Your Ref: OWPC16133
Our Ref: WA/76/17/PL 18-10-2017
Please ask for:
Ross Leal

5 No. dwellings with associated car parking, garaging, landscaping & bin storage & the creation of 2 No. new accesses onto Wandleys Lane. This application is a Departure from the Development Plan.

Land South of Wandleys Farm Wandleys Lane Walberton

Thank you for your internet representation made on 2nd November 2017 which has been recorded as '**an objection**' with the comments as follows:

SITE OVERVIEW AND
VISIBILITY SPLAYS
1:500

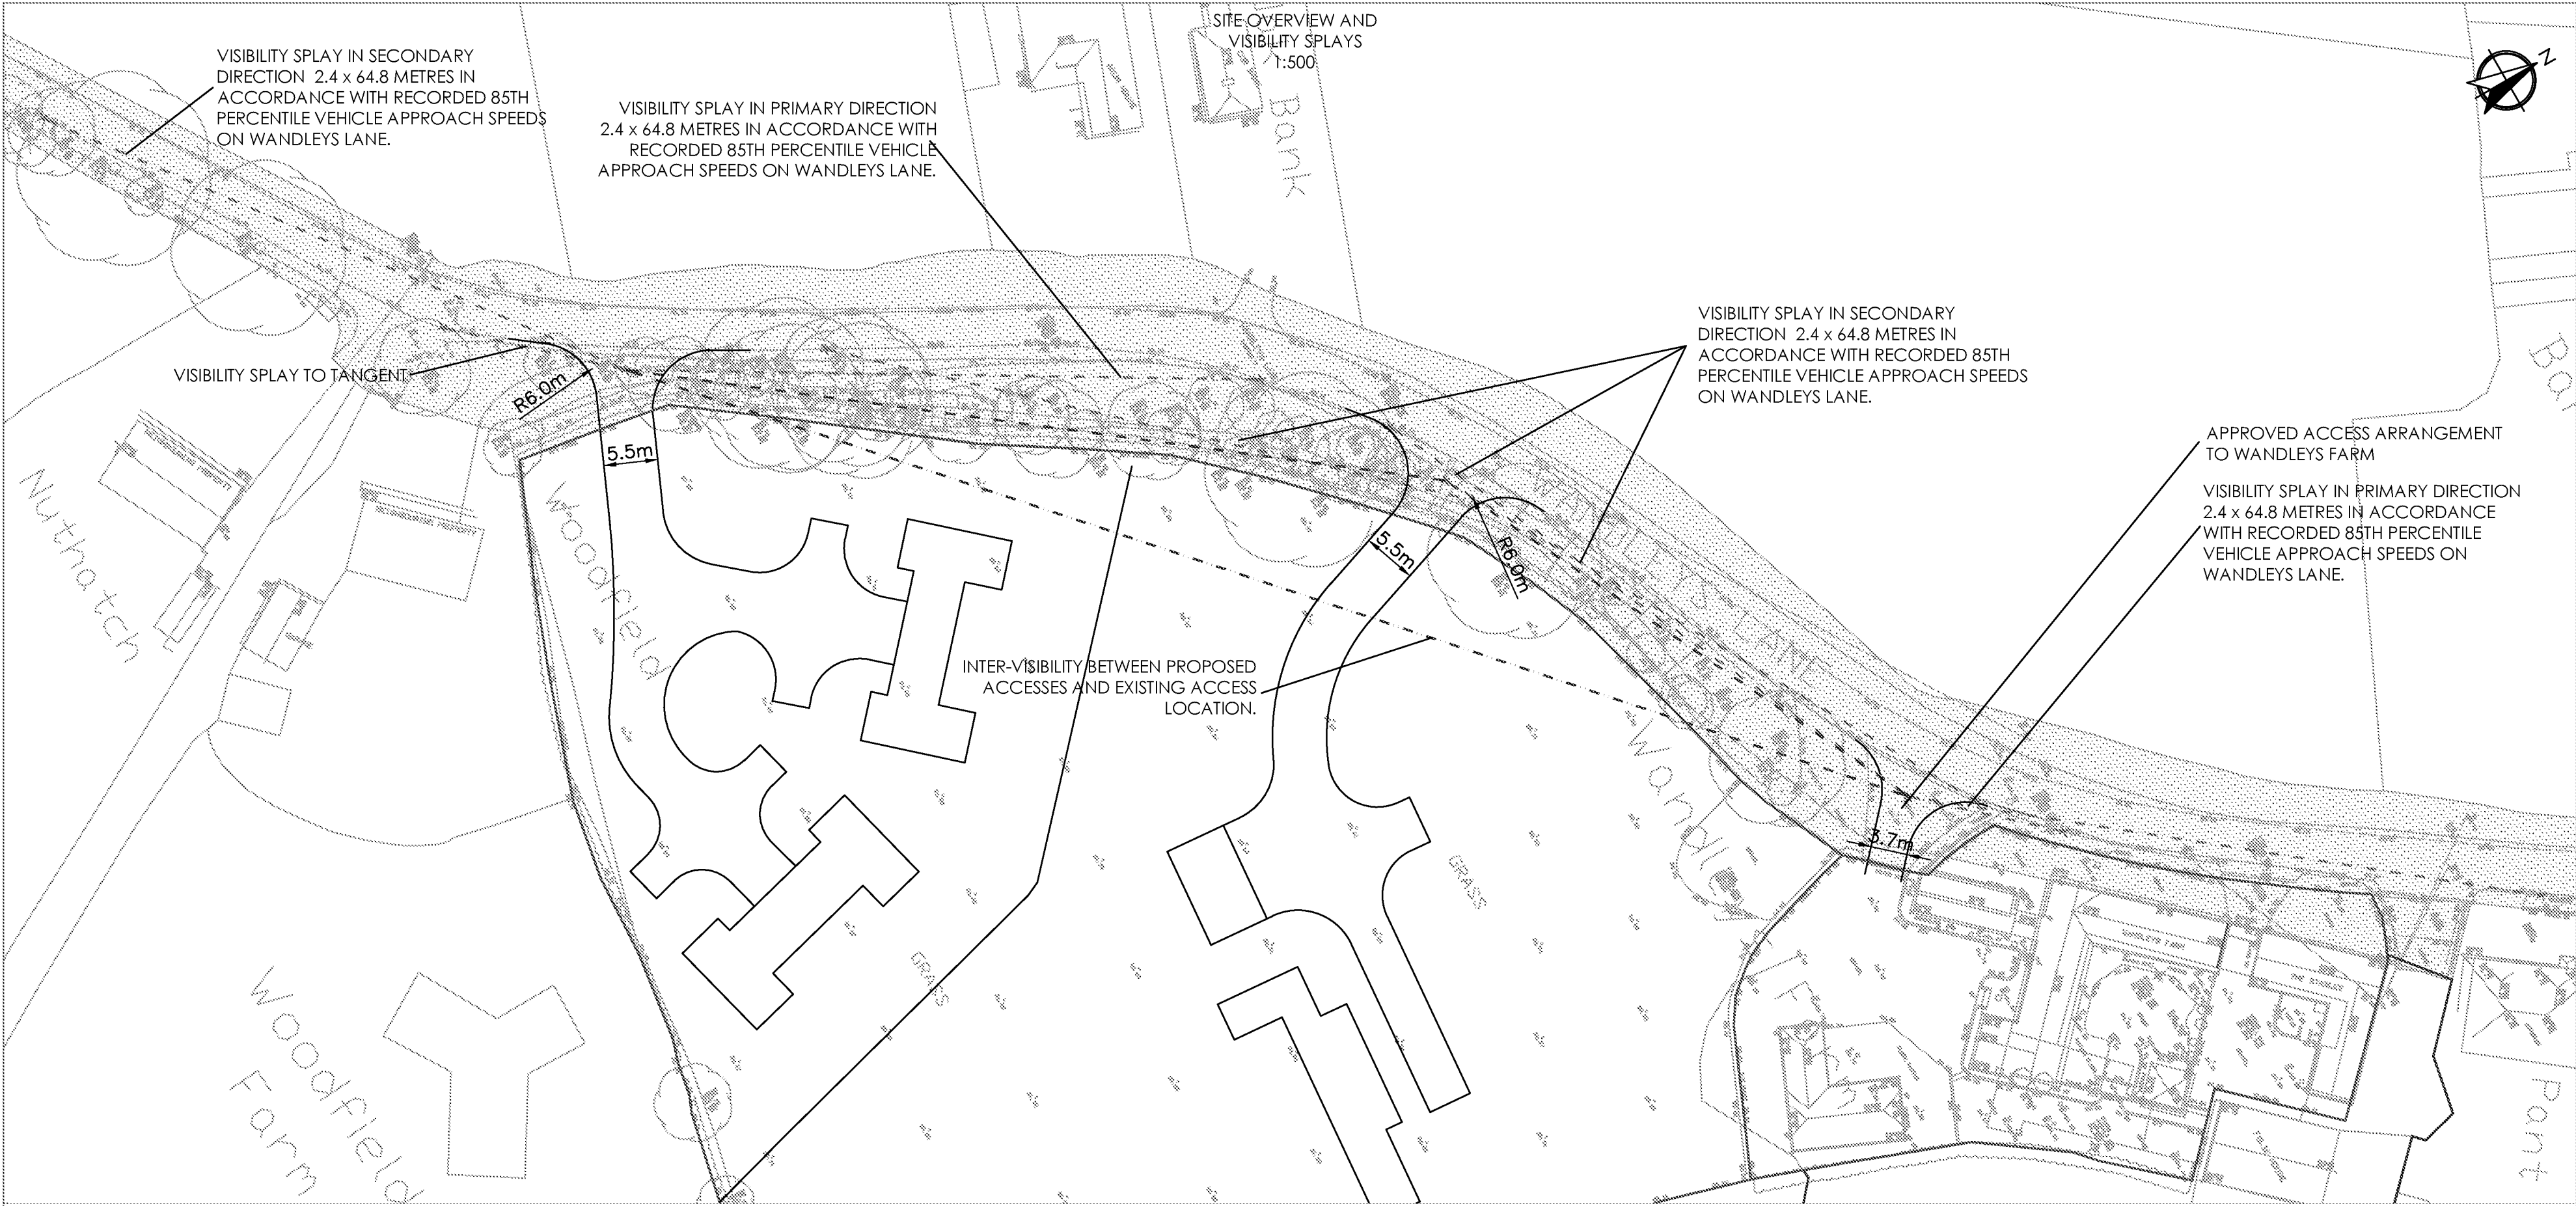
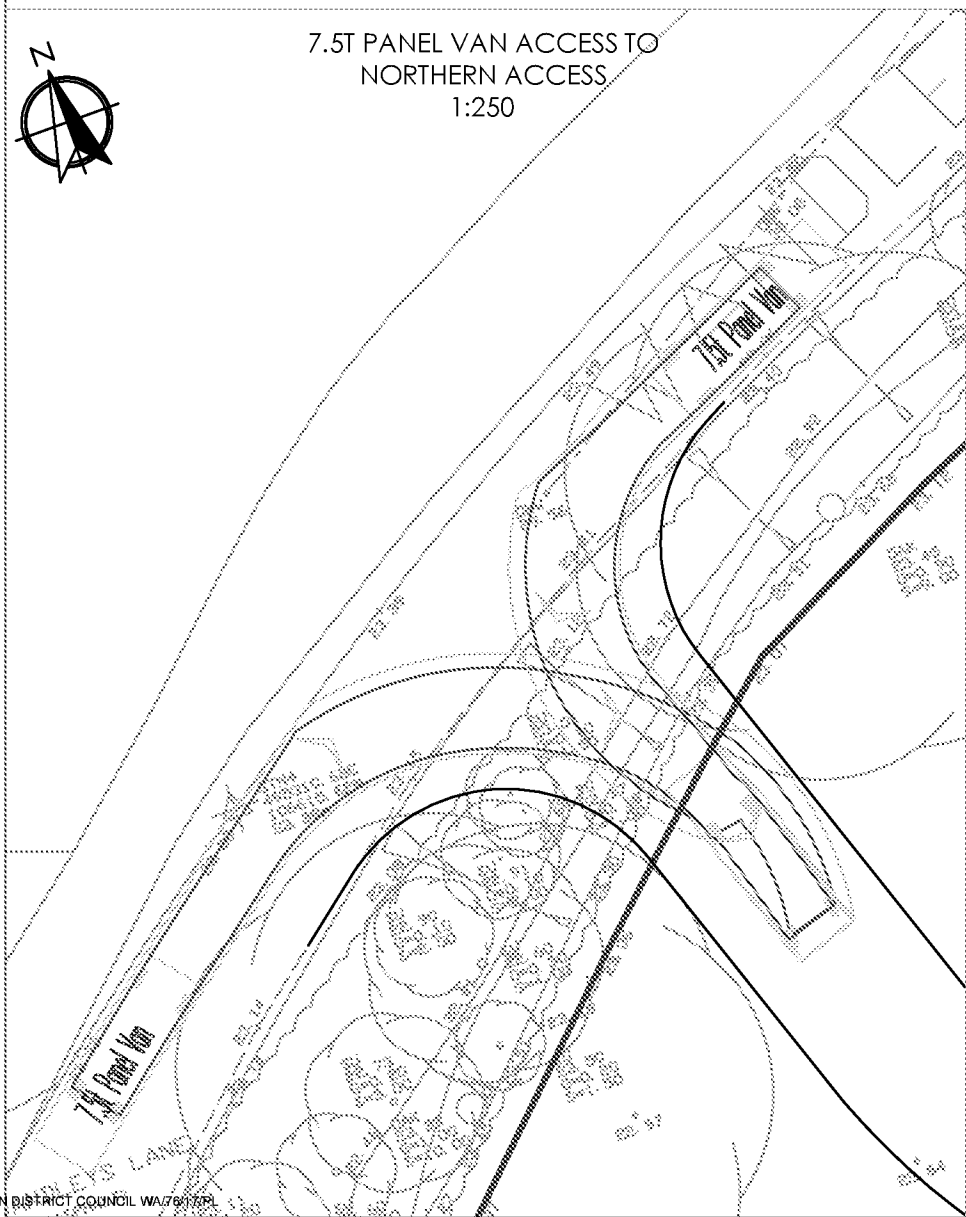
The proposed exact entry point is, by far, the most dangerous point along Wandleys Lane, being a 'low light', double-blind bend on a very narrow single lane, with no pavements, traffic speed control or street lighting. I use this part of the lane on a regular basis, and the number of near misses I have had is close to a miracle.

Never the less, this lane will soon be significantly affected by application WA/73/17/OUT, where a doubling, even tripling, of the number of cars will use the southern part of the lane to get to the schools and to Bognor Regis via the A29 to avoid the A27, so the dangers of access at that point along the double-blind bend will be vastly increased.

Therefore, some form of mitigation or solution should be applied before this application is considered.
